Appeal Decision

Appeal Ref: 6005832

Woodfold Park Stud, Woodfold Park, Mellor, Lancashire BB2 7QA

- The appeal is made under section 78 of the Town and Country Planning Act 1990 (as amended) against a refusal to grant approval required under Article 3(1) and Schedule 2, Part 1, Class A of the Town and Country Planning (General Permitted Development) (England) Order 2015 (as amended).
 - The appeal is made by Mr Chris Ellison against the decision of Ribble Valley Borough Council.
 - The application Ref is 3/2025/0899.
 - The development proposed is rear single-storey extension to detached dwellinghouse.
-

Drawing No: BB355- 104- Fb
Purpose of Issue: Planning

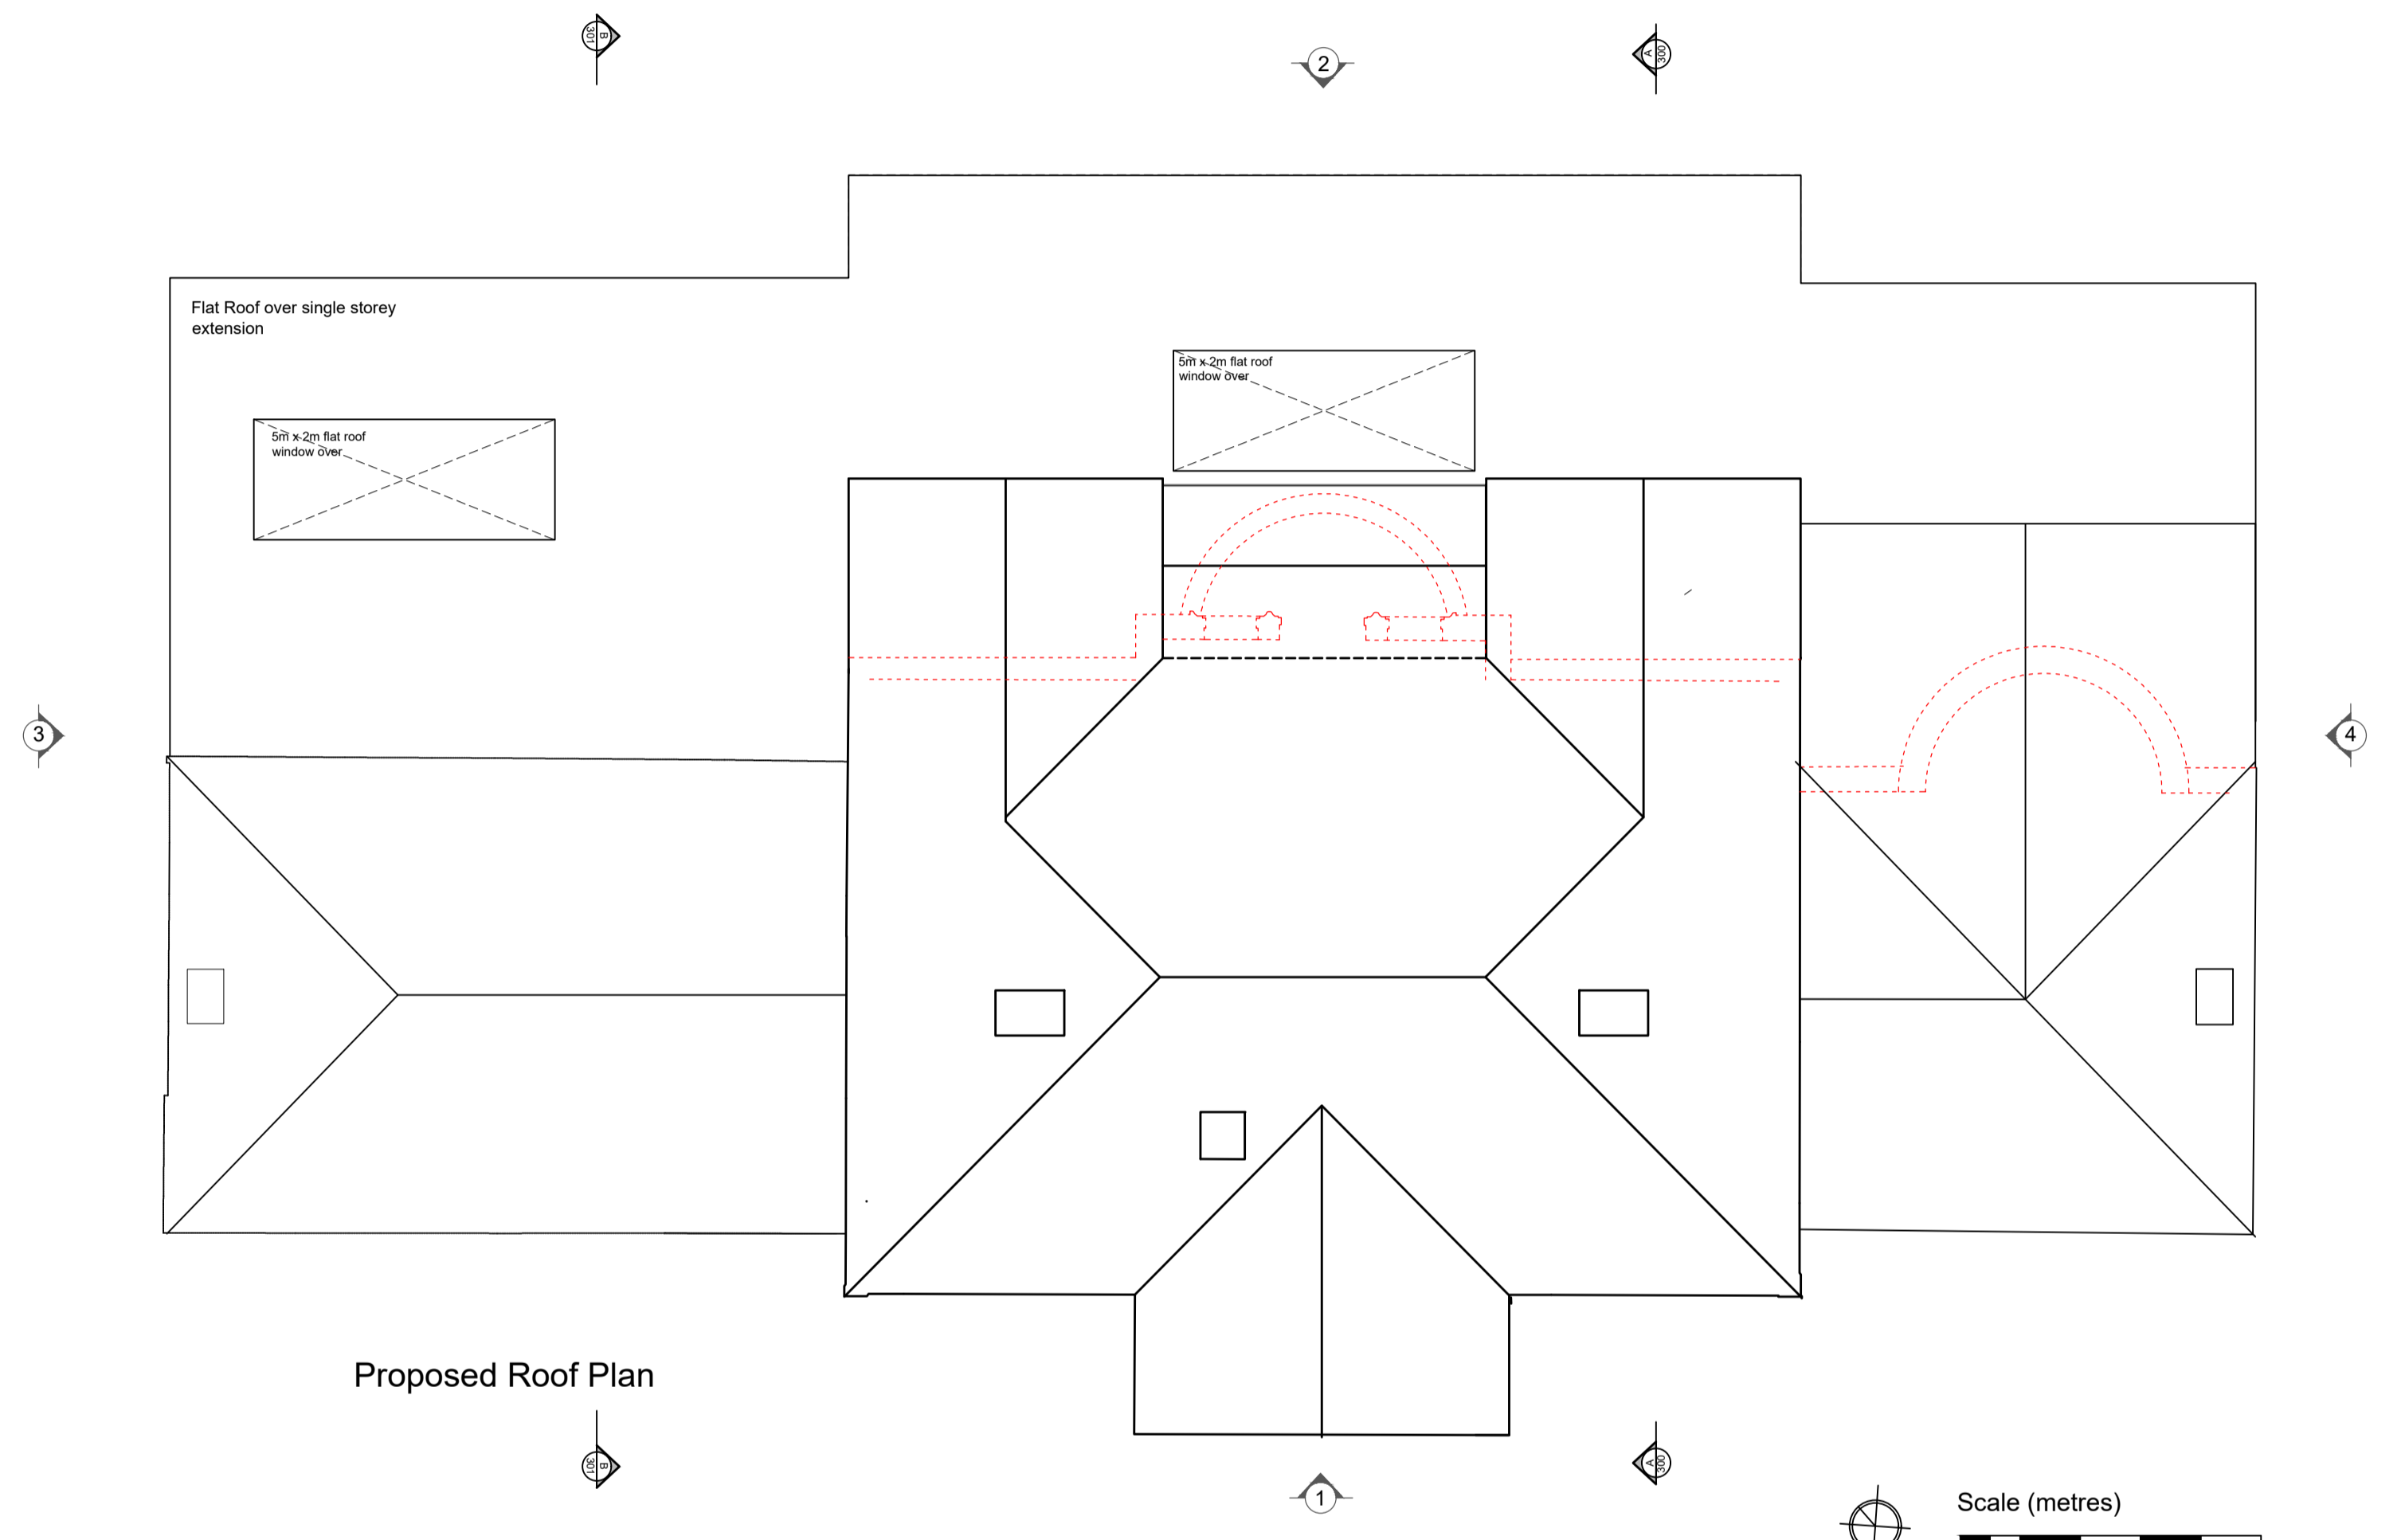
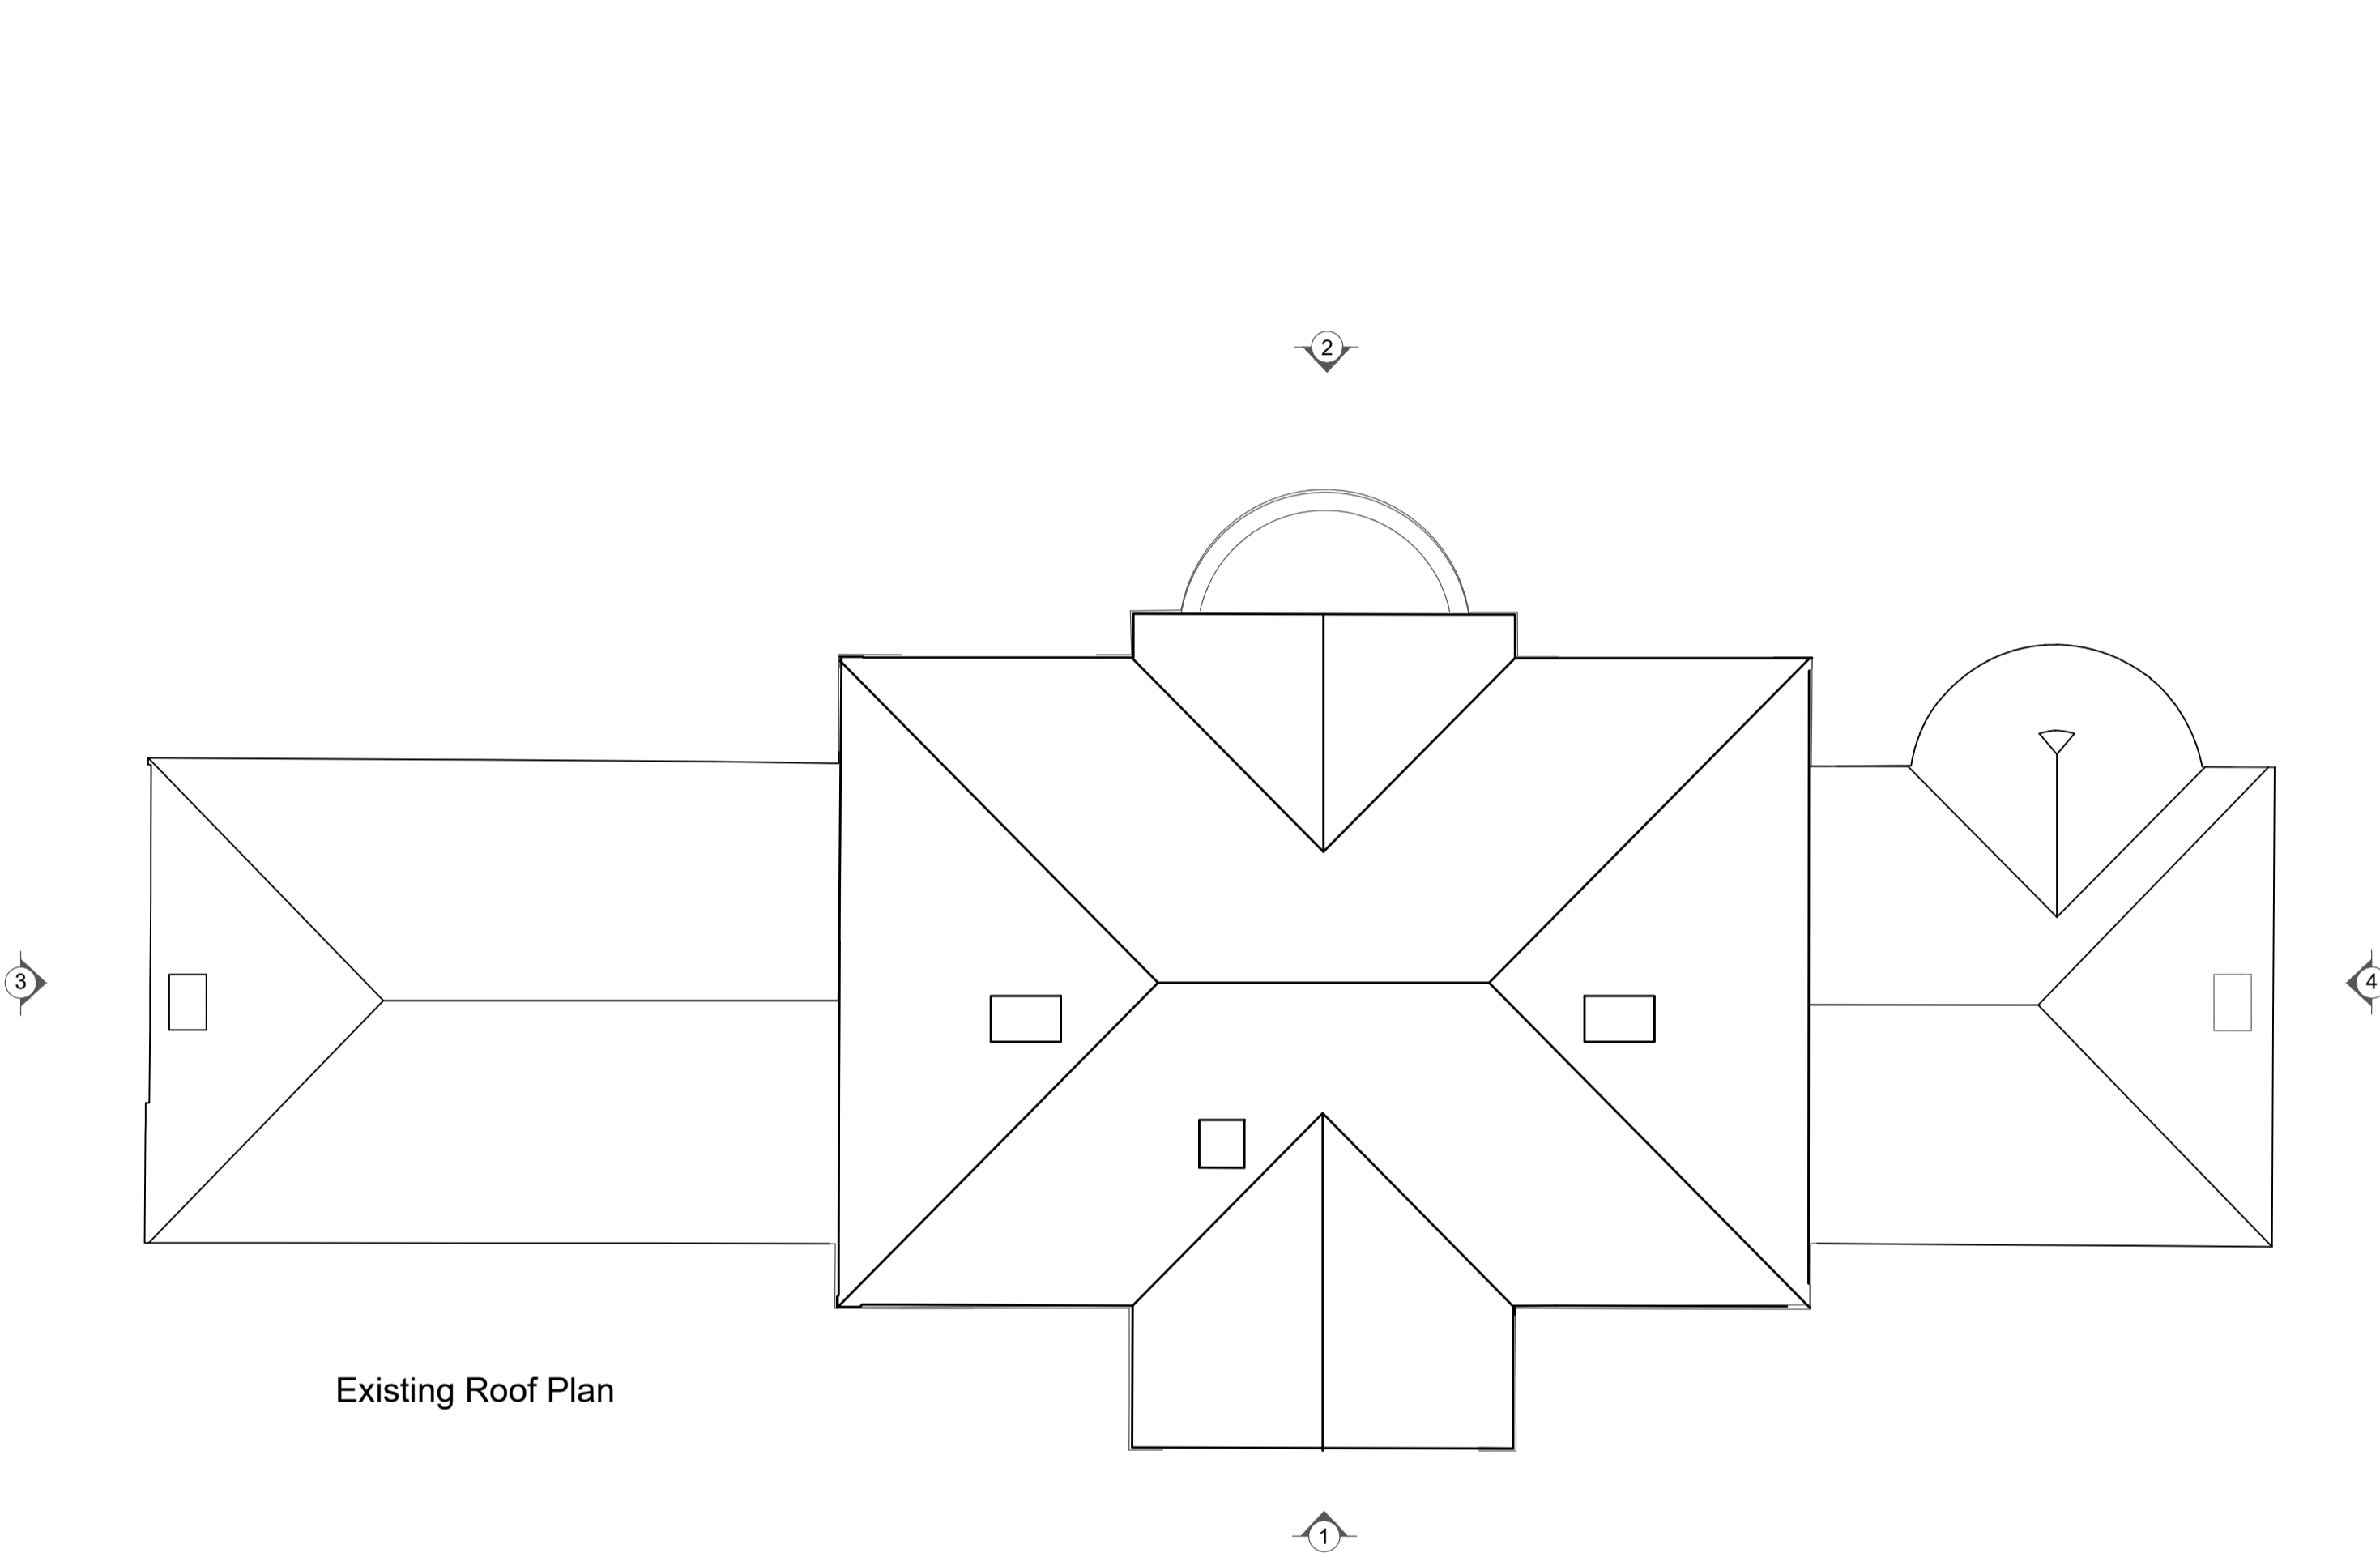
4. Clarification was sought from both parties regarding which plans were considered by the Council when they made their decision. The responses confirm that the amended elevation and roof plans¹ were requested by the Council during the consideration of the application. Whilst the proposed plans include a 2-storey extension, I noted on my site visit that this had not been constructed. I have therefore determined the appeal based on the amended plans, but only insofar as they relate to the appeal proposal for a single storey extension.
